**Section 75W Request to Modify the Minister's approval of Project Application 06_0250 (Mod 7)
– Seaside Boulevard, Fern Bay**

Thank you for your email dated 8 January requesting Council's comments for the above development proposal. The modification seeks to redesign the subdivision layout in the North East Precinct of Fern Bay.

Figure 3: Comparison of Approved and Proposed Footpath/Cycleway

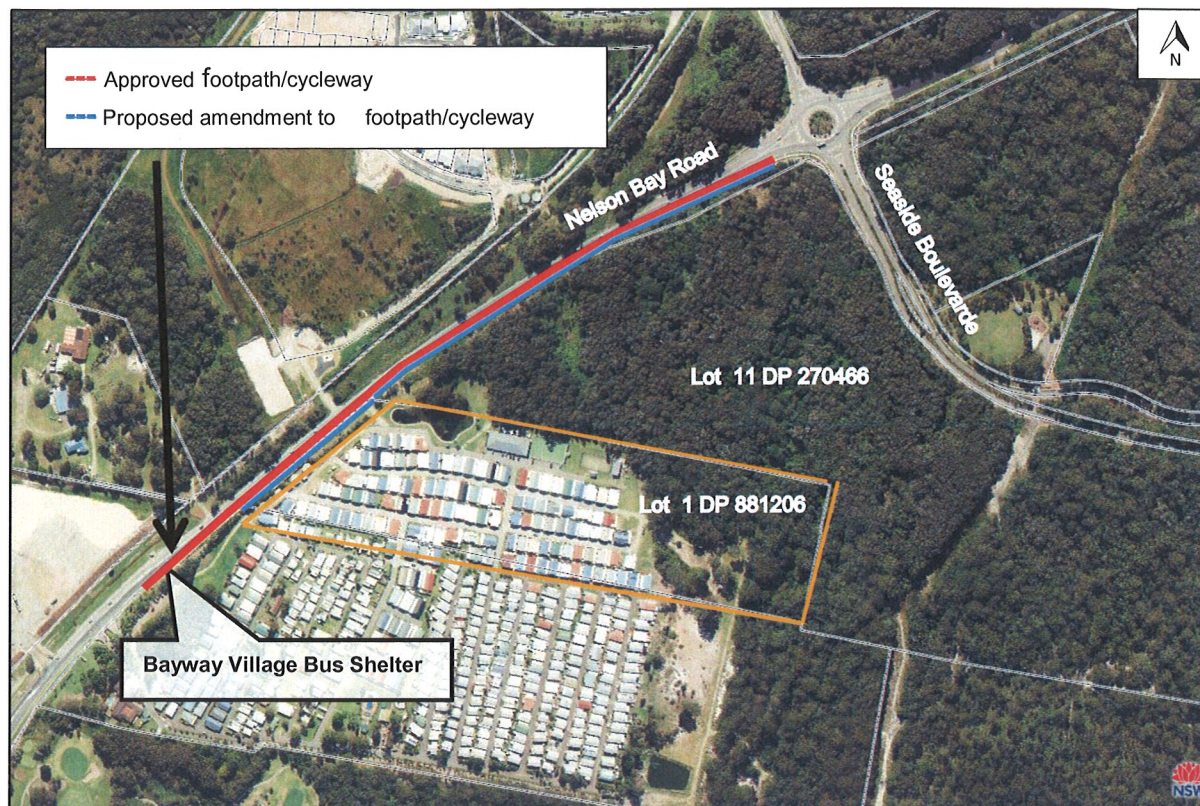
It is acknowledged that modification 6 of the proposal is also currently being assessed by the Department of Planning, whereby condition B4, requiring the construction of a shared path alongside Nelson Bay Road is proposed to be removed. Council has reconsidered its position on this issue following a presentation of a new alternative option by the RMS, and a number of concerns have been raised.

The proposed path represents a critical piece of infrastructure that will greatly improve safety for cyclists and pedestrians along this very busy road. The proposed path is a critical link for alternative transport between the Seaside Boulevard residential development and the Fern Bay and Stockton community facilities.

Council understands that the property boundary issues identified may make it difficult to achieve a best-practice outcome in terms of separation of the path from the road. However, as identified by RMS (in discussion), in the area where road reserve width does not allow for a full-width off-road shared path to be constructed, it will still be possible to provide alternative treatment that will improve pedestrian and cyclist safety that would be acceptable to Council and RMS.
